Reference: A/18/8/PL for Application for Variation of Condition 2 imposed under A/173/16/PL to read "the development to be carried out in accordance with the following approved plans ADC962/04 REVA, ADC962/13 & ADC962/14 relating to revised position of rooflights on east, north 7 south elevations. This application affects the Character & Appearance of the Angmering Conservation Area at Land Rear of 1 To 6 The Cottrells Angmering

Location: Land Rear of 1 to 6 The Cottrells, Angmering

Ref: Drawing ADC962/14: Elevations and Sections:

A		Layout amended		10.11.17	
Rev		Description		Date	
Job Reference		Client			
New House The Cottrells Angmering, BN16 4AF		AM Homes Ltd			
Drawing Title		Drawing No		Rev	
Ground Floor Plan		ADC962/04		A	
Date	Scale	Dwg Size	Plot Style	Drawn	Checked
24.04.17	1:100	A3	ADC-red	TGS	AD

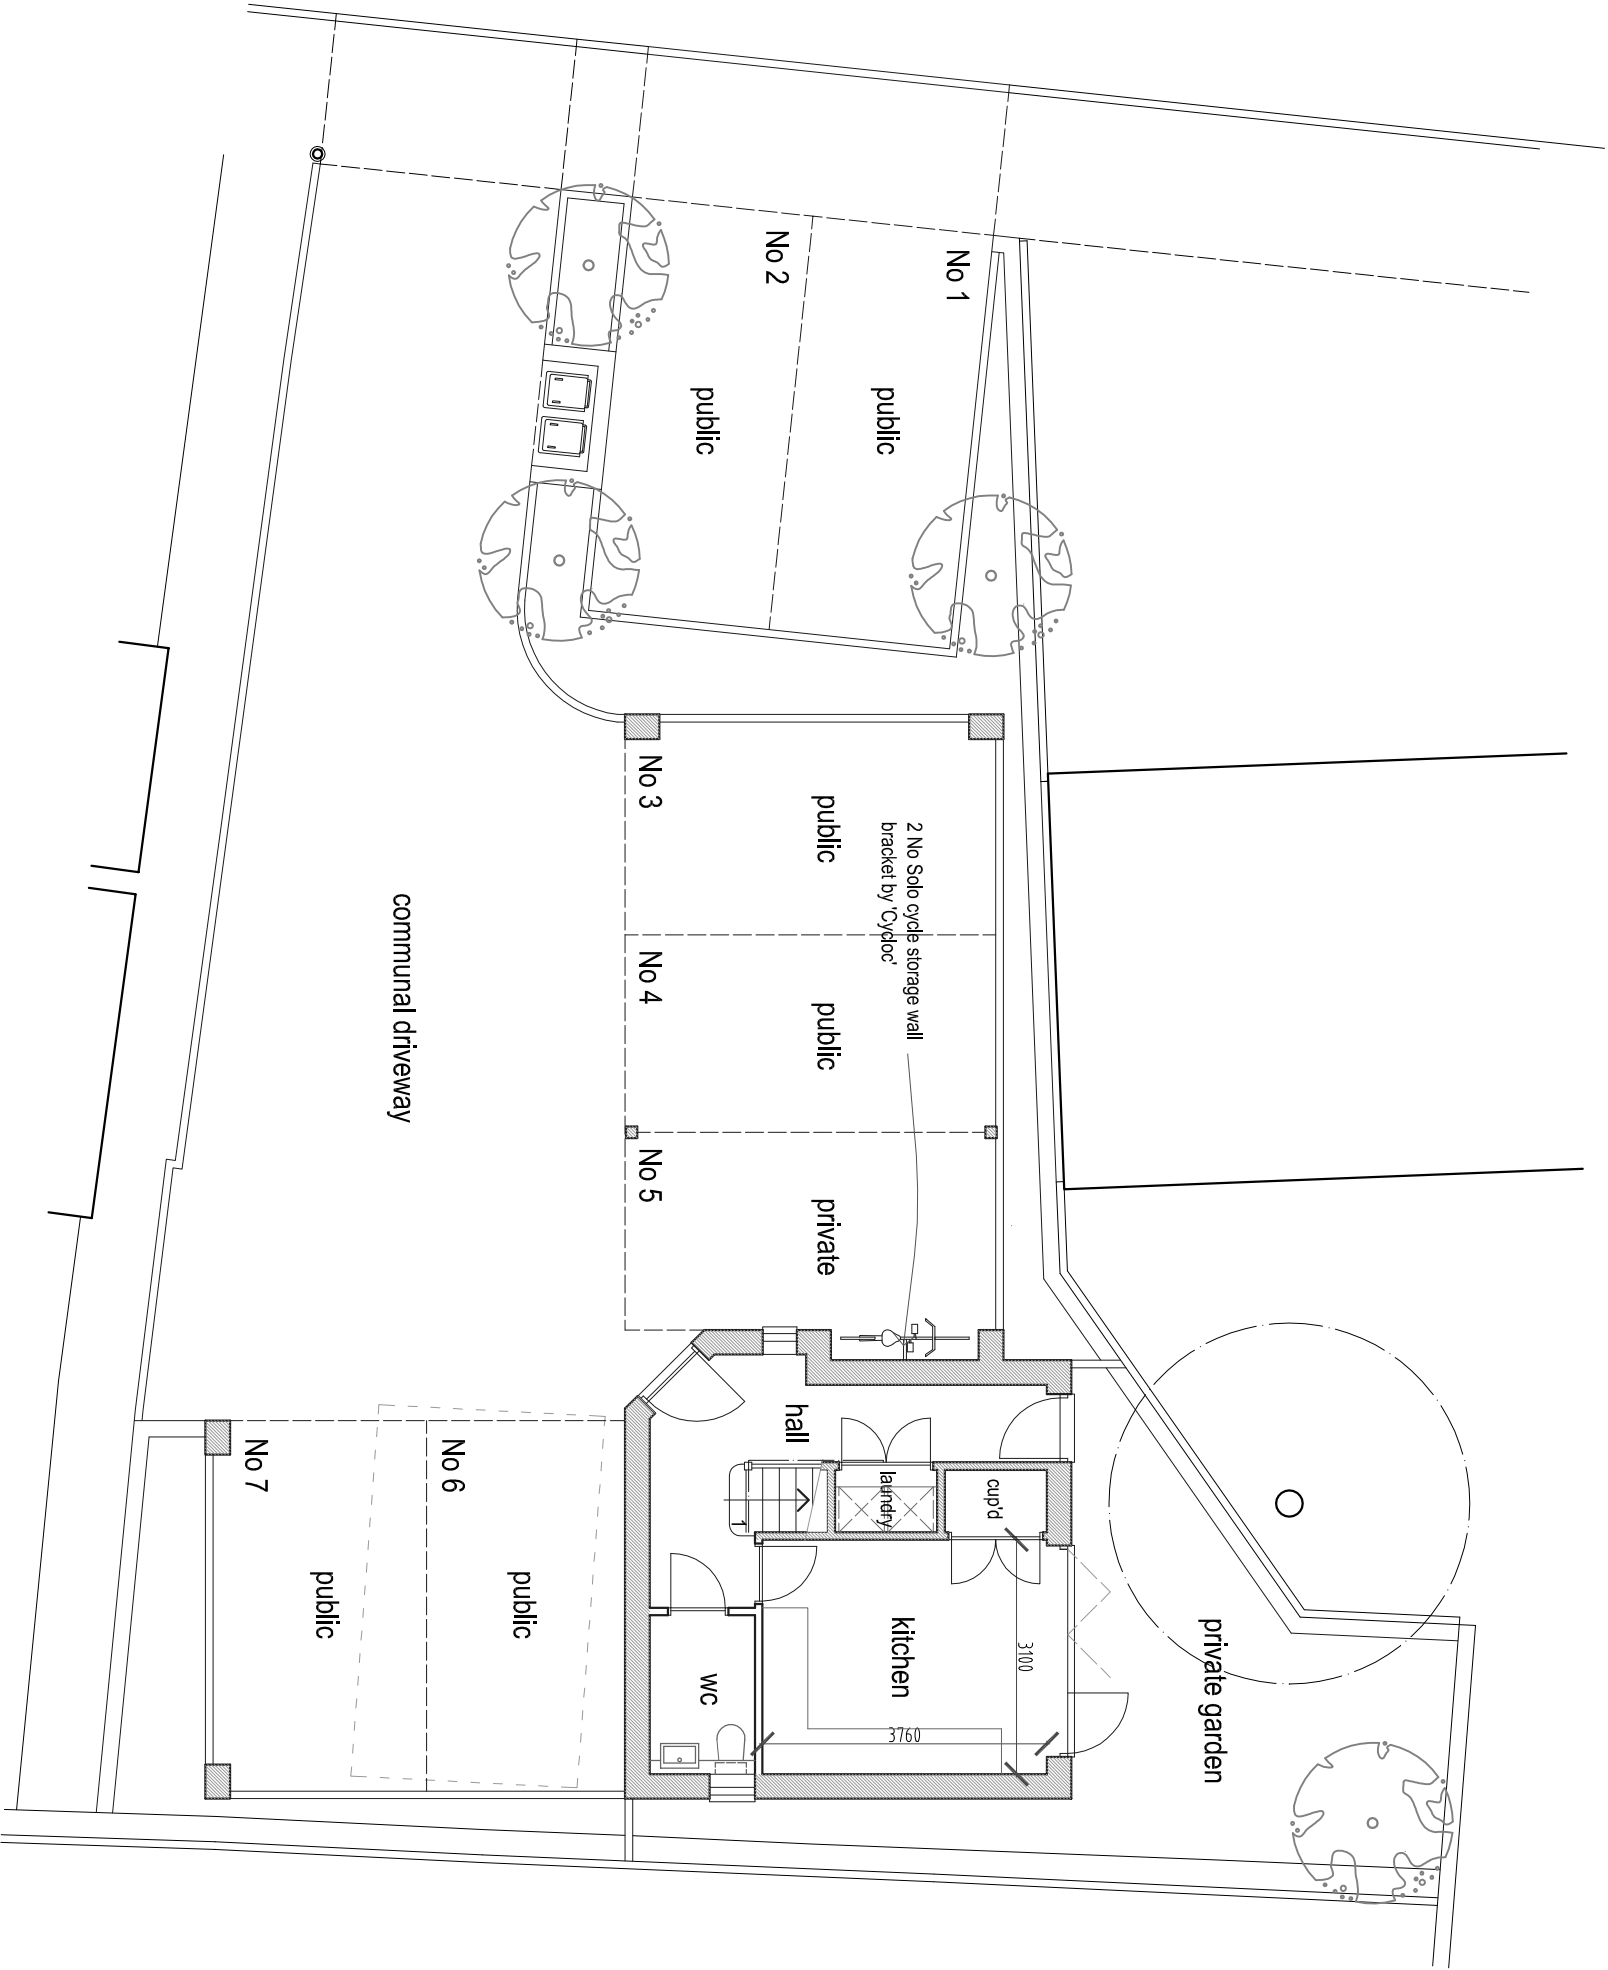
I am believe that the wall adjoining my property (on the south side of public parking space labelled 7 on the plans) has been built larger than on the submitted plans, at the wrong angle and is contravening building regulations by obstructing access to man hole covers for drains that connect to properties 4,5 and 6 The Cottrells.

Although I am not a surveyor I have taken measurements from the submitted plans and compared them with measurements I have taken from the site. I found the wall on site to be 5.45m whereas using a scale rule the

wall on the plans show it at 5m. I therefore question if the building has been positioned differently to the positioning shown in the submitted plans. These may seem like small measurements but on a plot this size they are significant.

The internal reconfiguration allows for the potential rearrangement of the rooms to increase the overall accommodation in the dwelling. The creation of a downstairs corridor and stairs external to the kitchen facilitates moving the kitchen upstairs and creating a third bedroom downstairs. I believe that it has already been confirmed with Building Compliance that the plumbing has been installed upstairs for the kitchen.

Rev	Description	Date
Job Reference New House The Cottrells Angmering, BN16 4AF		
Client AM Homes Ltd		
Drawing Title First Floor Plan & Roof Plan		Drawing No ADC962/13
Date 16.01.18	Scale 1:100	Dwg Size A3
		Plot Style ADgrey.spl
		Drawn AD
		Checked AD

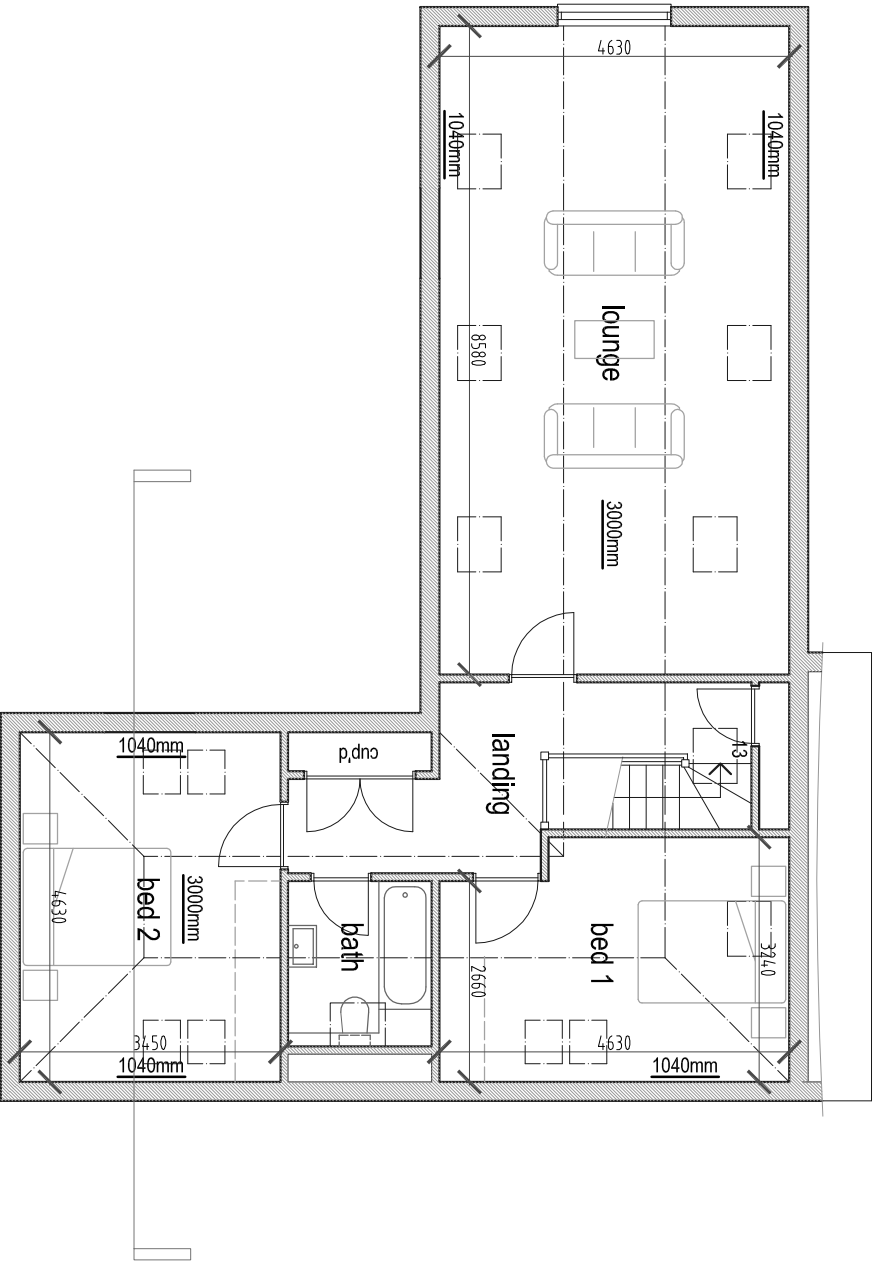
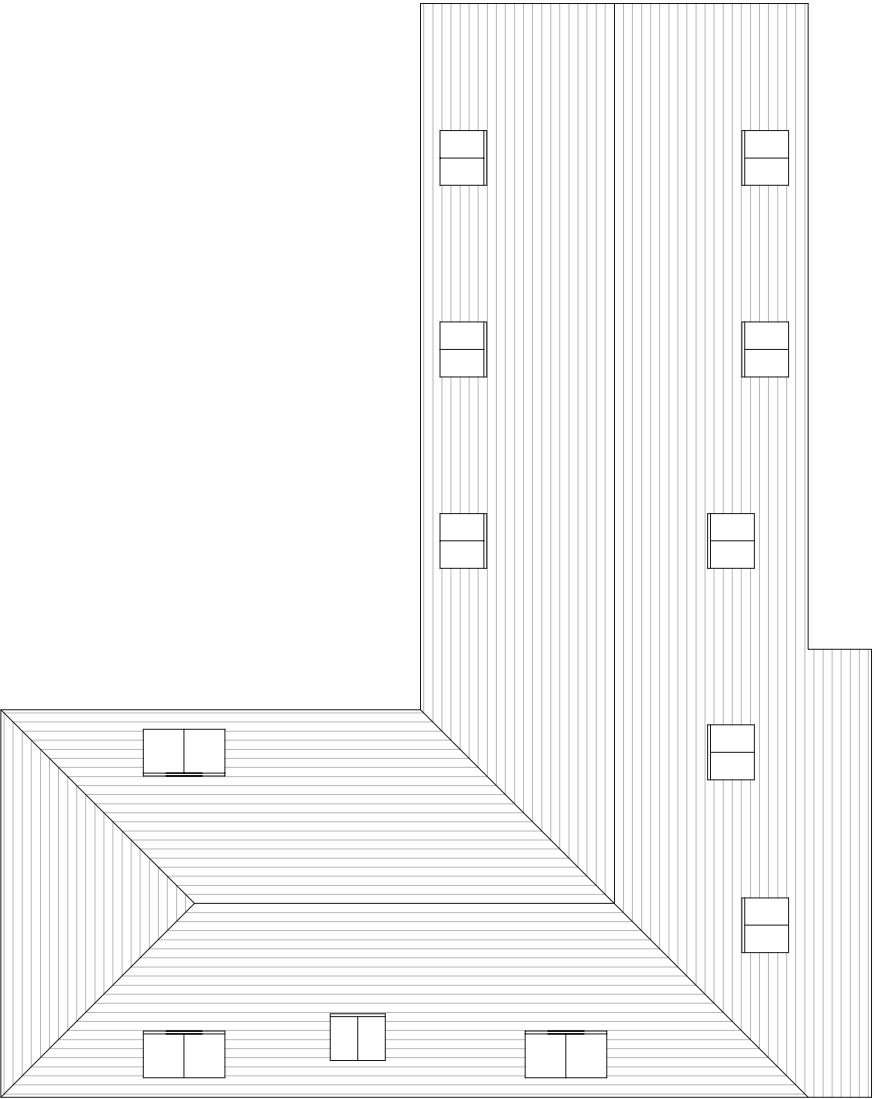
The elevations on this drawing are conflicting - they differ in their representations of the construction of the roof on the South Elevation. The West and East elevations on this drawing show a hip end on the roof that forms the south elevation as does ADC 962/13. The south elevation drawing however shows a barn end. The building that has currently been constructed shows a barn end so it can only be presumed that this the developer's plan.

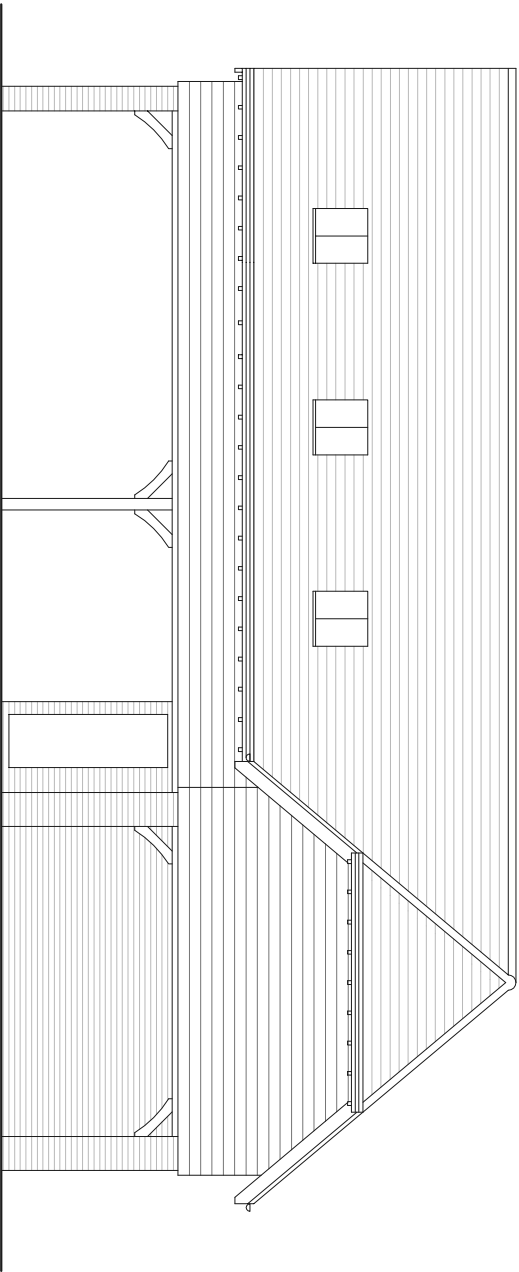
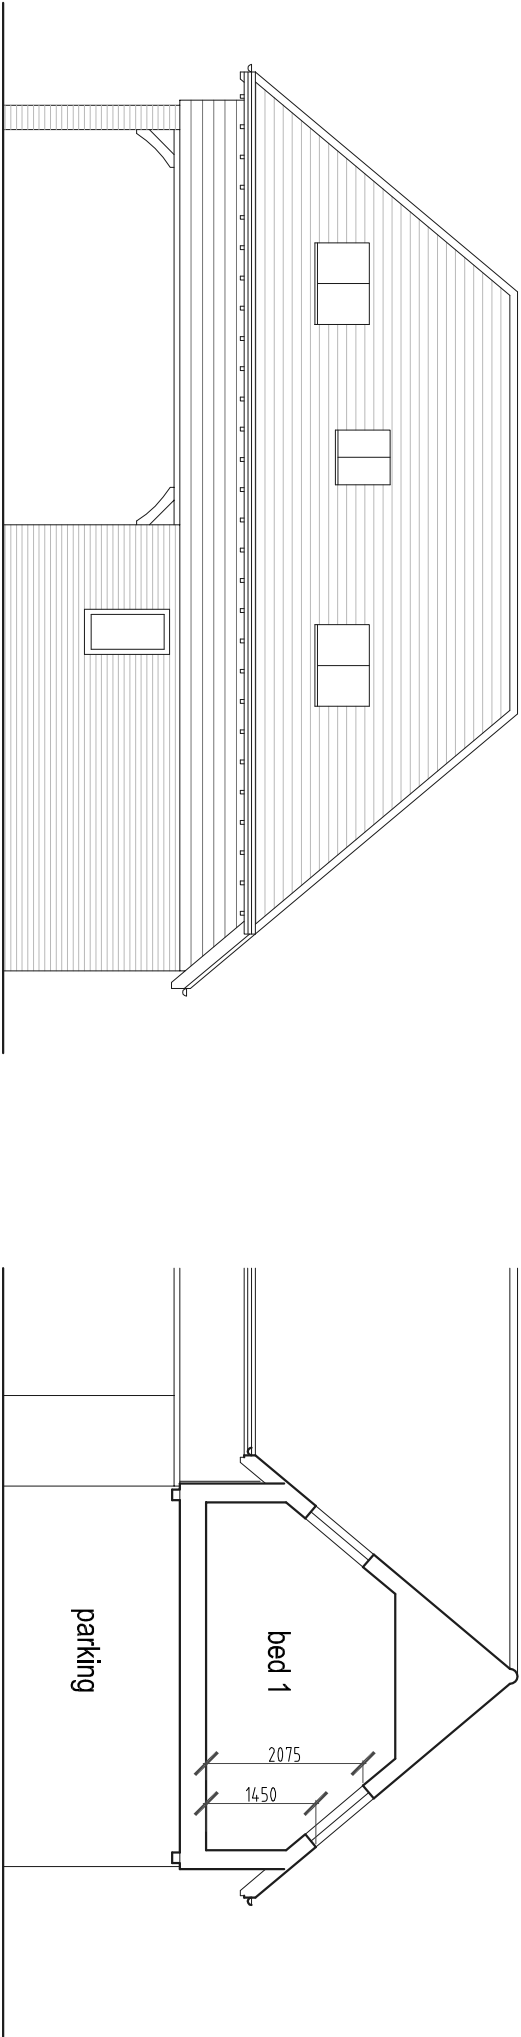
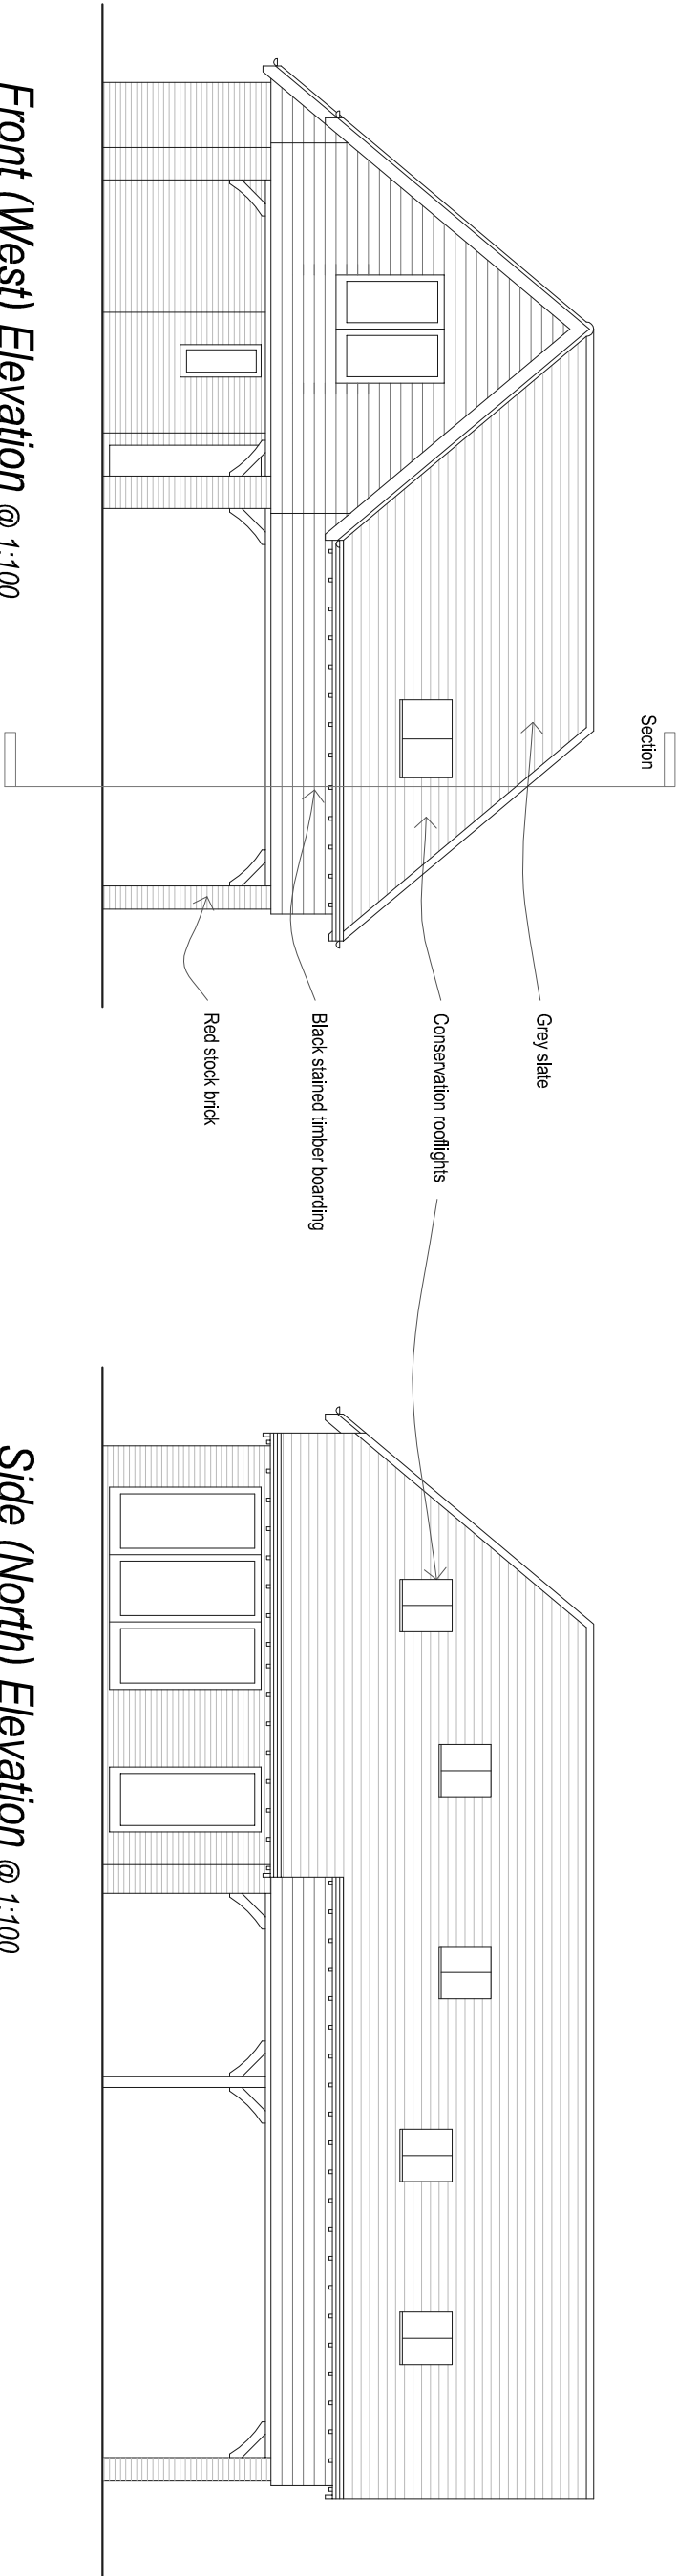
The application wording is misleading, the wording references only the roof light locations whereas the drawings and current construction also show a major deviation from the approved plans.

I object strongly to the barn end. It is totally unacceptable, it has a dramatic and negative affect on mine and other properties. It is overbearing, out of keeping with its environment and is an attempt by the developer to build a bigger accommodation. I am beyond words as to how such a fundamental variation to the approved plans has taken place.

Although I am not an architect or surveyor, I do not believe that the currently constructed roof ridge and the current west elevation window position would allow for a hip to be constructed without the roof and guttering overhanging my property. To achieve the hip end I believe the roof ridge needs to be reduced.

I request that the roof is taken back to the hip end the original approved application (A/173/16/PL) and the positioning of the building to be considered so that there is no overhang over the site's boundaries and all future maintenance can be achieved from within the site itself.

The building has been fitted with windows not the approved escape roof lights. This gives the windows a more domineering appearance and is not in sympathy with the conservation area. The approved plans section illustration show the lowest point of the windows to be 1.5m from the internal floor, the submitted plans drop them to 1.45m from the internal floor. This means that we can see directly into the property, indeed I have spoken to the builders working in one of the windows from my upstairs window. Clearly when the property is occupied this would compromise the surrounding properties' privacy. All along we have been told that the occupiers will not be able to look out of these windows, clearly this is not the case at all.

The plans also deviate from the approved plans by showing red brick and not timber posts. These are currently industrial style steels so:
